City of Albuquerque

RE: DRAINAGE SUBMITTAL FOR ALLEY GRADES AND FOR PHASE II OF THE
C.A.B. BUILDING RECEIVED NOVEMBER 19, 1985 (J-13/D27)

PROJECT TITLE: C.A.R. Building ZONE ATLAS/DRNG. FILE #: J-13/027

RE: DRAINAGE PLAN FOR C.A.B. BUILDING (J13-D27) RECEIVED AUGUST 1, 1985

SITE DRAINAGE AND GRADING PLAN FOR THE C.A.B. BUILDING - LOT, A-1, LUNA PLACE 1011 LOMAS BLVD. NW

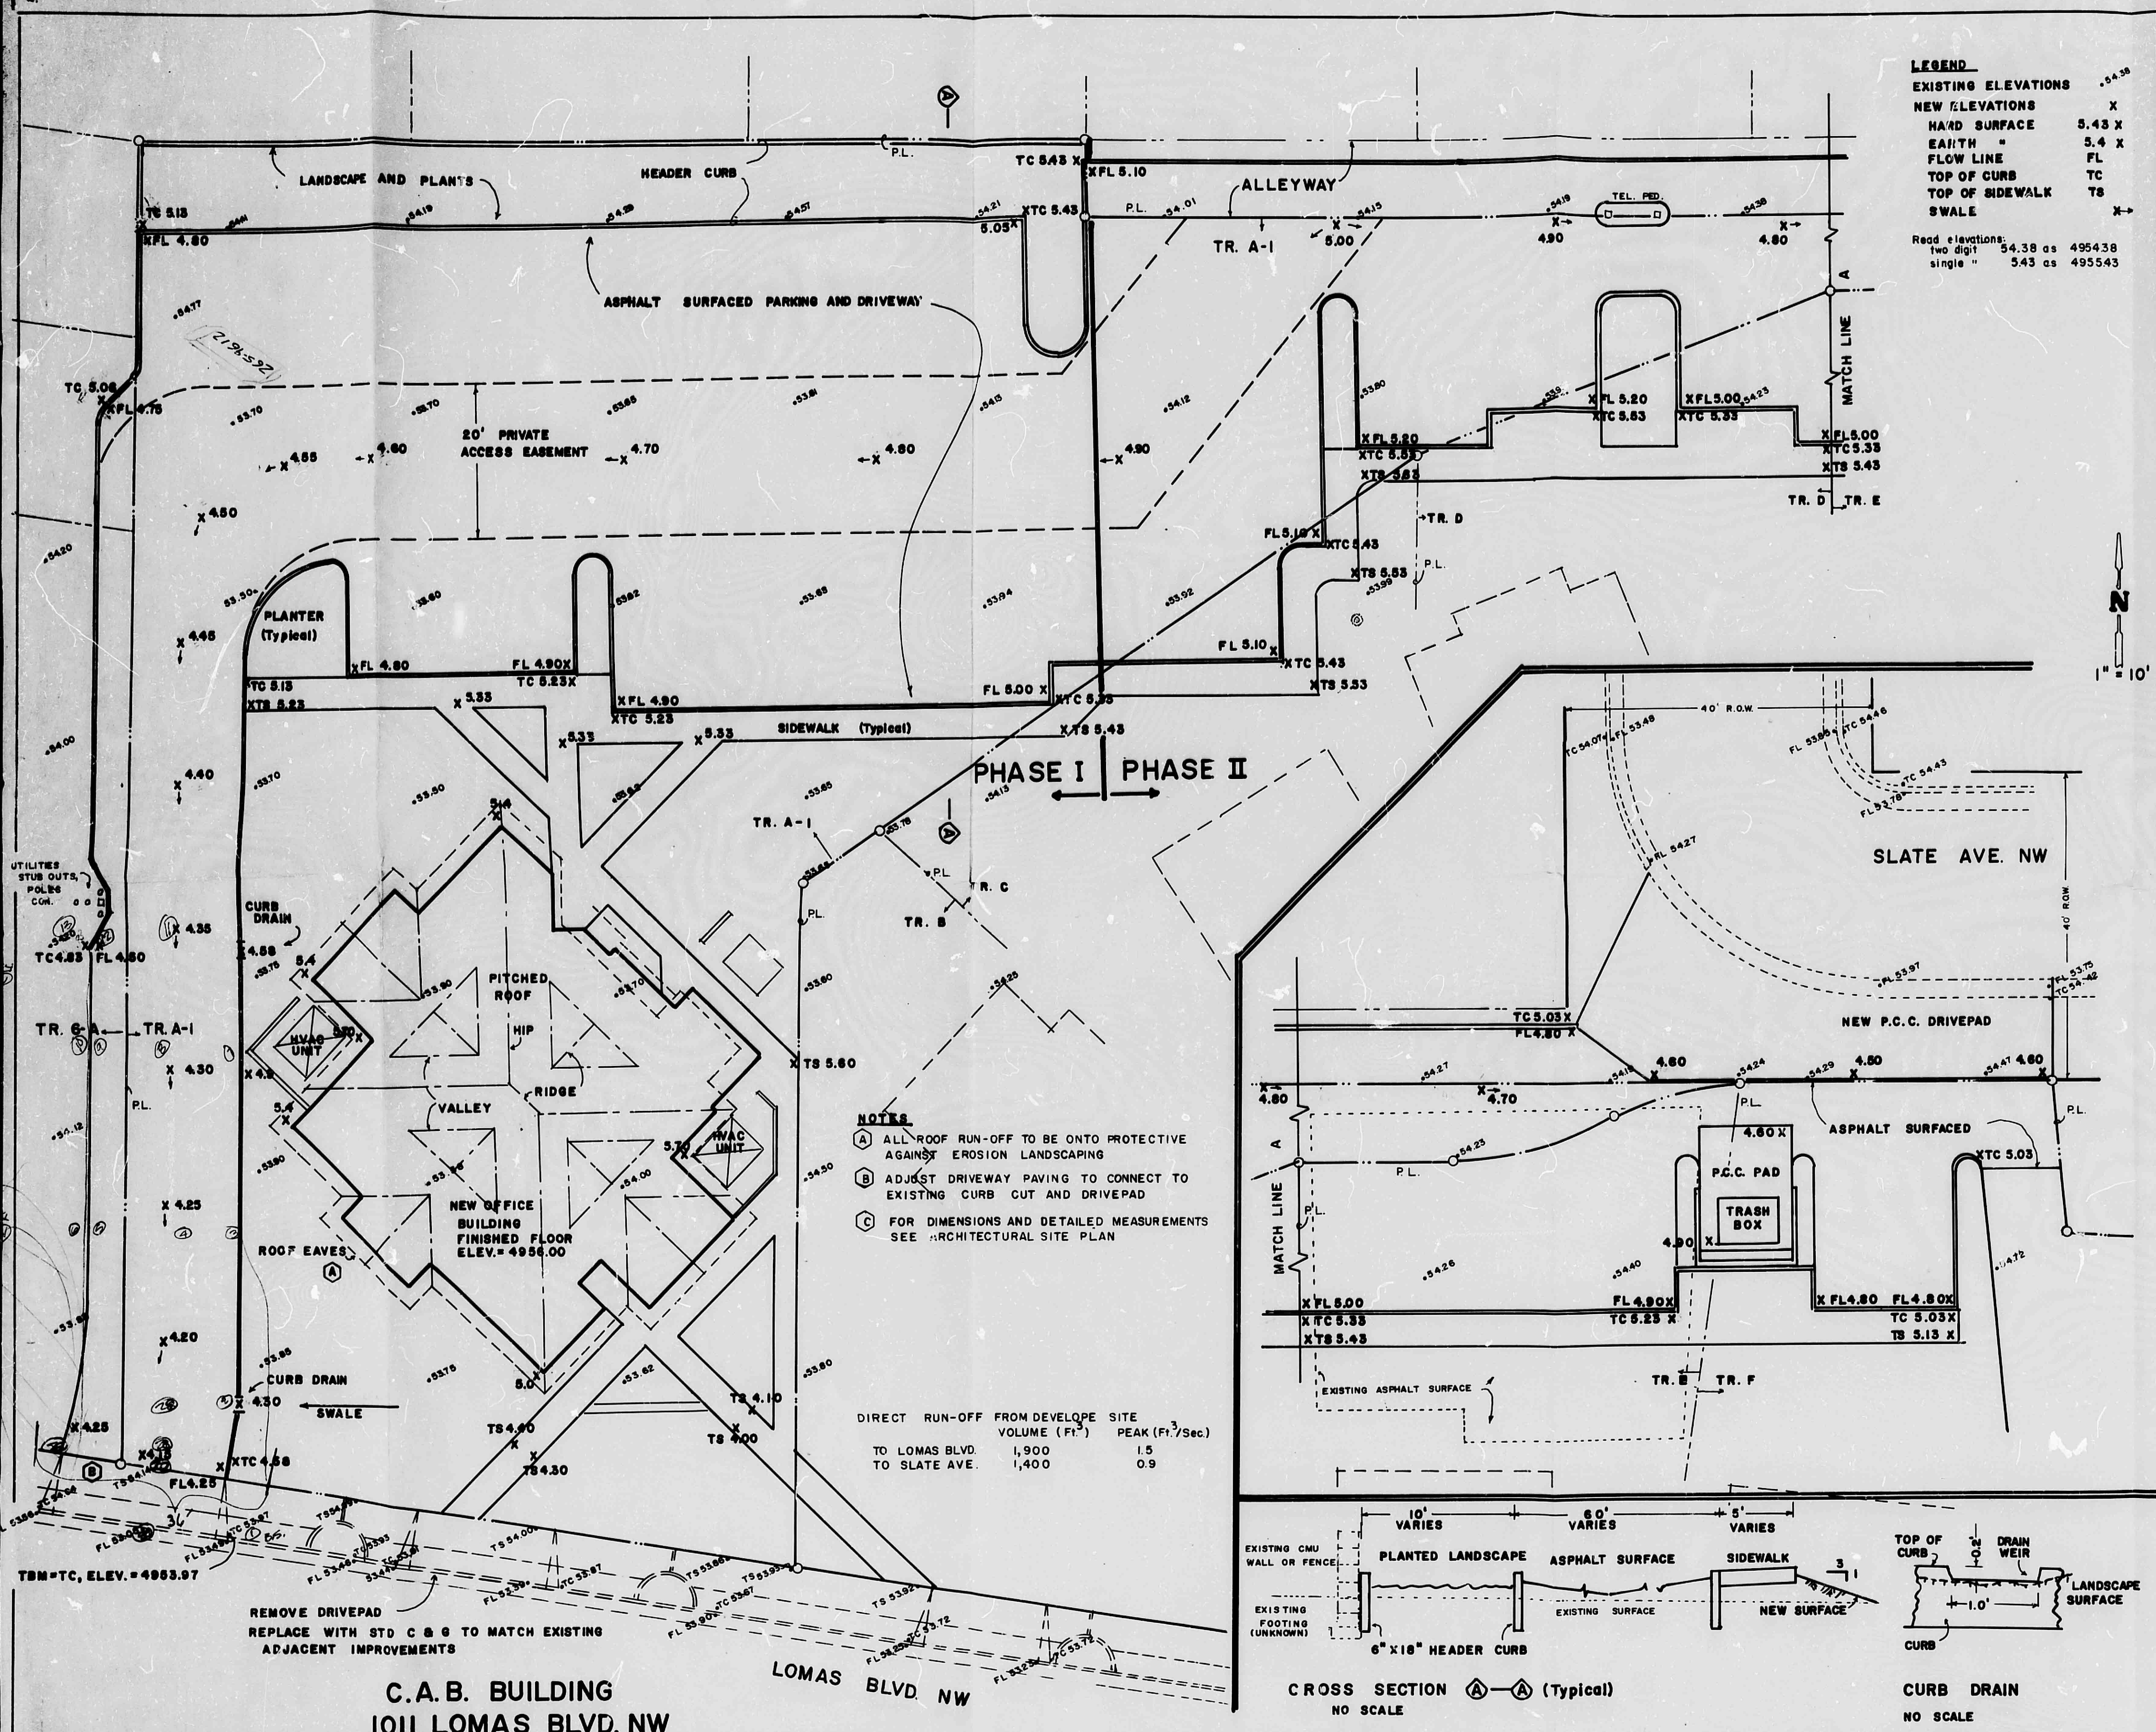
1. Work outside the property lines cannot be approved without appropriate easements and or agreements from adjacent property owners or replatting to incorporate the area.

2. Why was a "C" factor of 0.66 used for run off in Lomas Blvd. and 1.0 used for State Avenue? They are both impervious streets and a factor of 0.90 (minimum) should be used.

3. How will the roofdrains discharge to asphalt? The building is surrounded by landscaping (?).
4. The driveways not used are usually required to be removed and replaced with curb and gutter and sidewalk. This is not shown.

5. The finished floor elevation of the structure is required to have the complete MSL designation.
6. The public alley way along the west and north properties cannot be blocked without going through the proper procedure (DRB) for vacation.

7. City approved alley grades are required prior to building permit release.
8. There are several on-site existing structures. Are these to be removed or are they to remain in place?

9. Need to provide the location of the TBM on-site.

1. Documents are being prepared which will permit the construction of the paved driveway, parking area, and sidewalks on adjacent properties. Documents will also show easement for the across the property line drainage. Draft copies of these documents are attached. Please review these documents for adequacy to meet your requirements for work approval. The property owners have agreed informally to the conditions expressed in these drafts, but there will be some delay in obtaining signatures. Also attached are documents which were provided to the Albuquerque Planning Department in 1982 concerning the reciprocal parking for the Luna Circle complex. The present project, building of the C.A.B. Building and paving of the parking lot and access driveway, is a continuation of that earlier project. For information, see also zoning files AP-15 (4A-237).

2. The labeling of the calculations on page 4 of the Drainage Report was misleading in that the label "LOMAS BLVD." referred to the drainage basin that drained to LOMAS BLVD., and not to the drainage basin that included LOMAS BLVD. The drainage basins were described earlier in the report, and the abbreviated label then used. Attached is a revised page 4 which corrects the labeling. The "C" factors of 0.66 and 1.0 refer to the drainage basins.

3. The building Architect has elected to use drain diverters over the doorways and to use no collectors or gutters at the remainder of the roof eaves. The run-off from the roof eaves will fall undiverted to the surrounding landscape. Run-off which is not absorbed in the landscaped area will flow to the paved driveway through cuts in the curb between the driveway and landscaped area. These cuts are now shown on the drainage plan.

4. The driveway which is not required by the present site plan will be replaced with standard curb and gutter, with the sidewalk and brick imprint concrete consistent with adjacent right of way improvements. This construction will be covered by the appropriate City Permit.

5. The finished floor elevation is now shown as 4956.00, rather than the abbreviated 56.00. All elevations shown are based on the indicated Benchmark, 1-J13.4, elevation 4956.54.

6. The public alleyway along the west and part of the north side is in the process of being vacated through proper procedures. The final administrative procedures for this vacation will be completed within a few days. The current files on this action are at the City Property Management office at 123 Central Ave.

7. There is approximately 135 feet of alleyway along the northeast property line, connecting to SLATE AVE., that has not been vacated. A project is being prepared and will be submitted separately to the City Engineer for the necessary approvals for construction on that property. My understanding is that the option remains for a request for vacation of this alleyway, should such action be appropriate.

8. There are no significant on-site structures. Remnants of flower beds, garden walls, and outbuildings from previous uses will be disposed of during normal grubbing and clearing. Minor utilities structures, such as the telephone pedestals, may remain or may be replaced by sub-surface boxes, the issue still to be coordinated with the respective utilities.

9. A temporary bench mark is now designated on the drawing. The TBM is off site, due to the disturbance of all on site surface features during grubbing, clearing and construction.
